Zoning Committee Recommendation

Rezoning Petition 2022-139

April 4, 2023

Canvas Residential, LLC

SHEET NUMBER
RZ-1

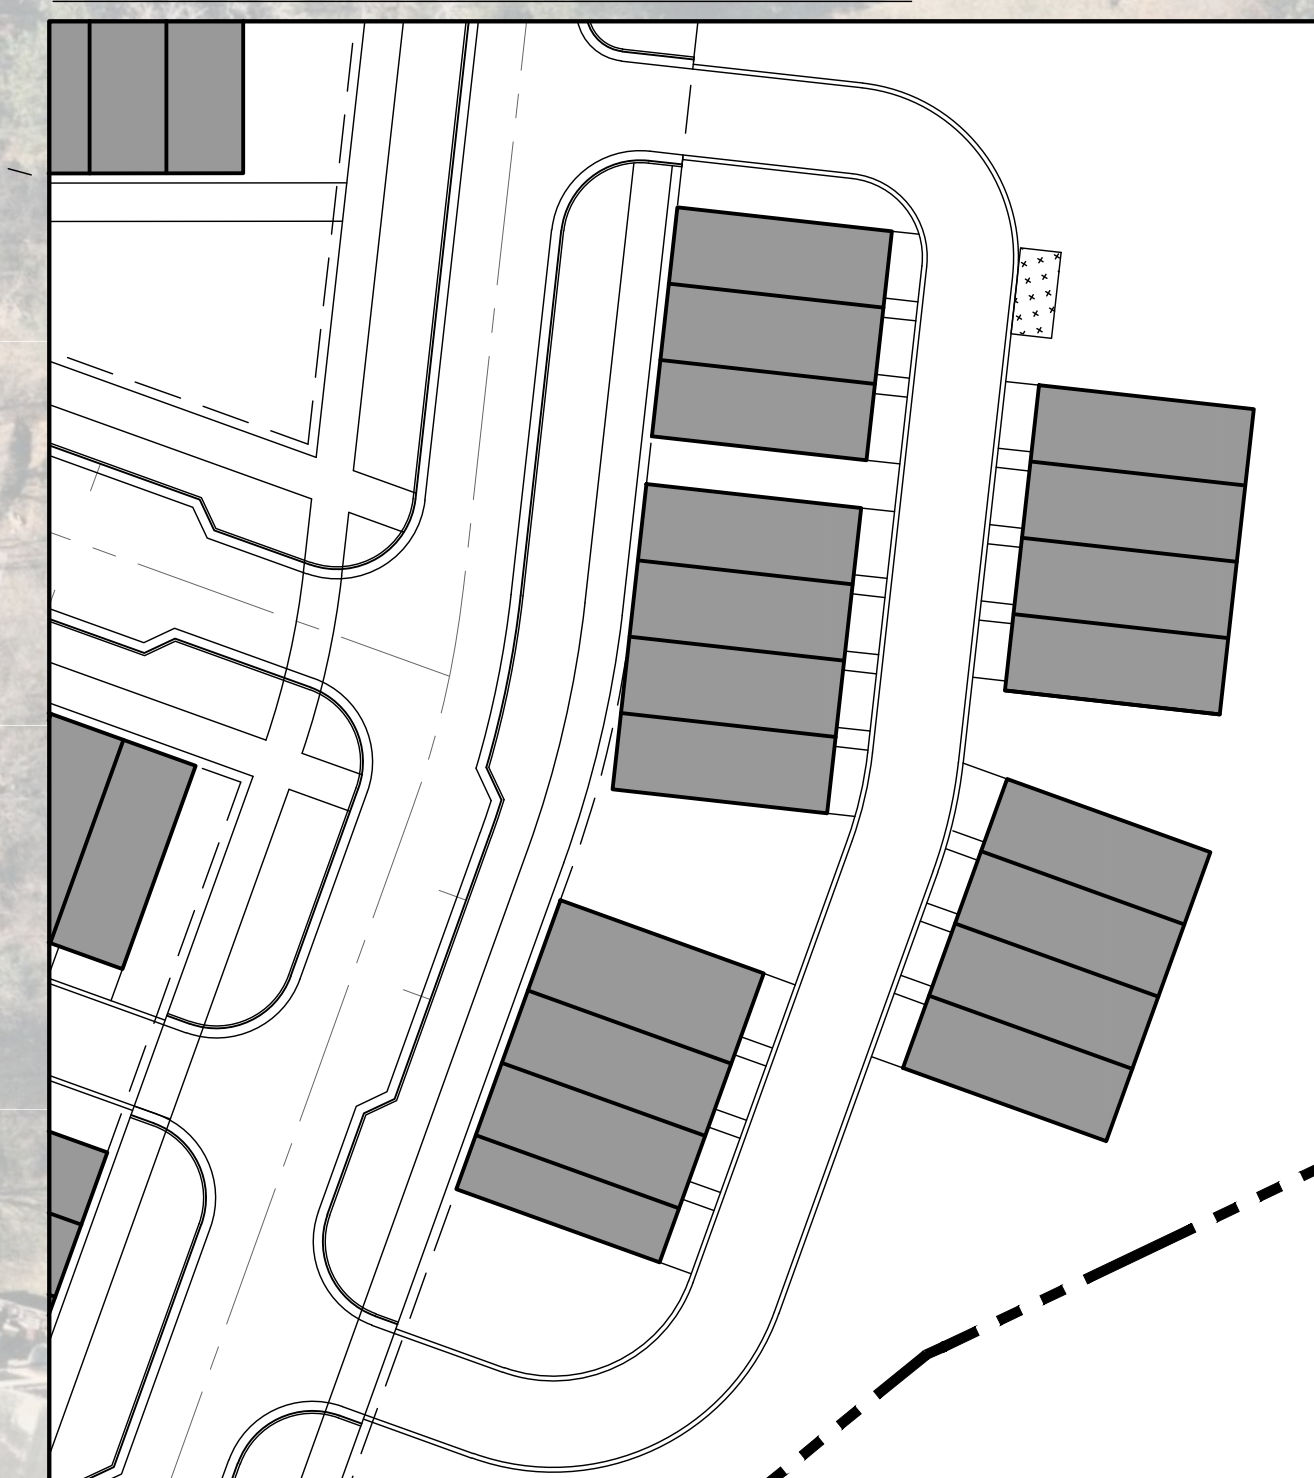
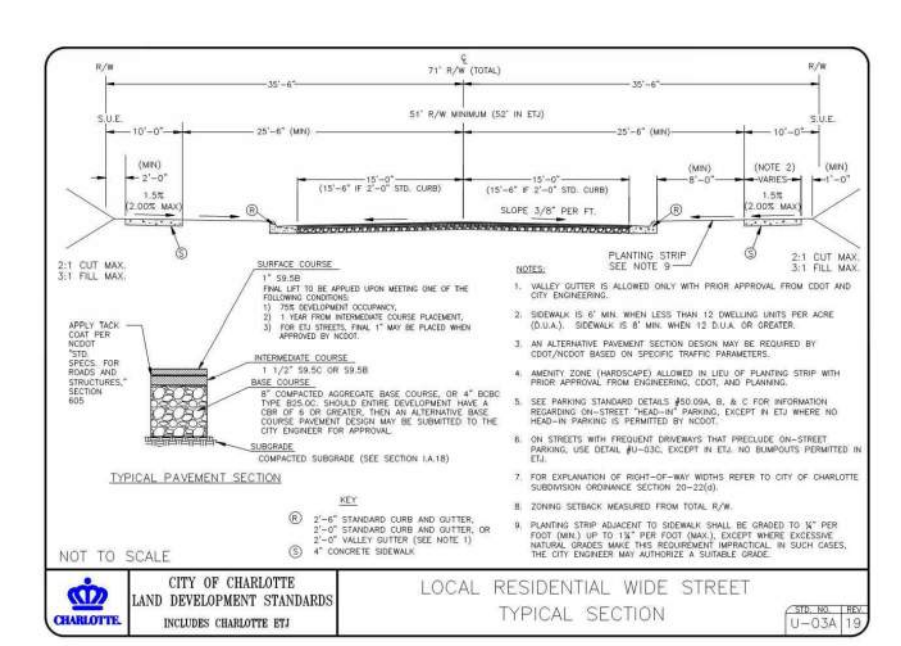
Chairman Gussman asked for clarification on the sidewalk width along William Ficklen Drive, the slideshow stated 6 feet but staff's presentation stated it would be 8 feet in width. Staff clarified that the sidewalk would be a minimum of 8 feet in width and that the slide was outdated.

Commissioner Lansdell stated that he had concerns regarding the distance from the intersection of William Ficklen Drive and Ben Craig Drive to the on-street parking along the private road. CDOT staff stated that the distance from the intersection to the first parking space meets CDOT standards.

PRIVATE STREET (BUILT TO PUBLIC STANDARDS) SECTION A-A

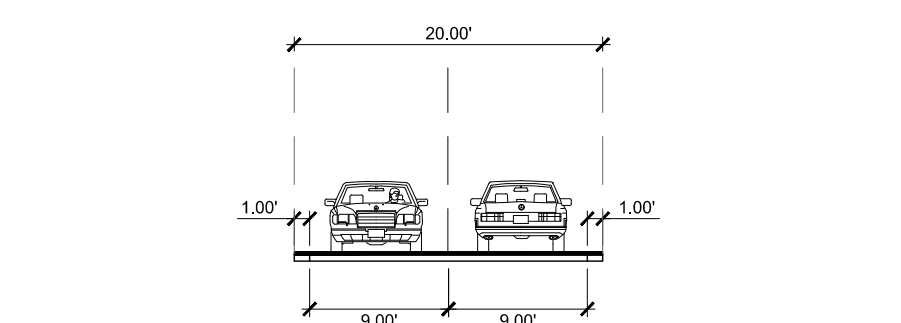
Commissioner Lansdell stated that he appreciated that the on-street parking was proposed to be located on a private street but asked for additional detail about the width of the private street. Staff stated that there is a standard detail for the street on the site plan and the detail proposes a CDOT "residential wide" cross section which includes 71 feet of right-of-way.

Commissioner Lansdell asked for additional detail about the width of the on-street parking in the standard cross section. Staff stated that the roadway was a typical 30 foot gutter to gutter width. Commissioner Lansdell asked for clarification about what was included in those measurements. Staff stated that the 30 foot width include on-street parking and that 30 feet was the entire width of the roadbed, not as measured from centerline. CDOT staff reiterated that this was standard detail and that there is 15 feet of pavement as measured from centerline with on-street parking, 9 feet without on-street parking, and that

adjacent to the intersection the roadway measures 20 feet from curb to curb.

Commissioner Lansdell stated that he hoped to see updates to the private roadway design in the upcoming revised site plan. Staff asked for additional detail regarding what changes he hoped to see, stating that the only outstanding issue still to be addressed was to add a note that CDOT requested. Commissioner Lansdell stated that he would like to see the detail for the private street. Staff stated that the detail is included on the site plan and that it is a standard detail from the Charlotte Land Development Standards Manual.
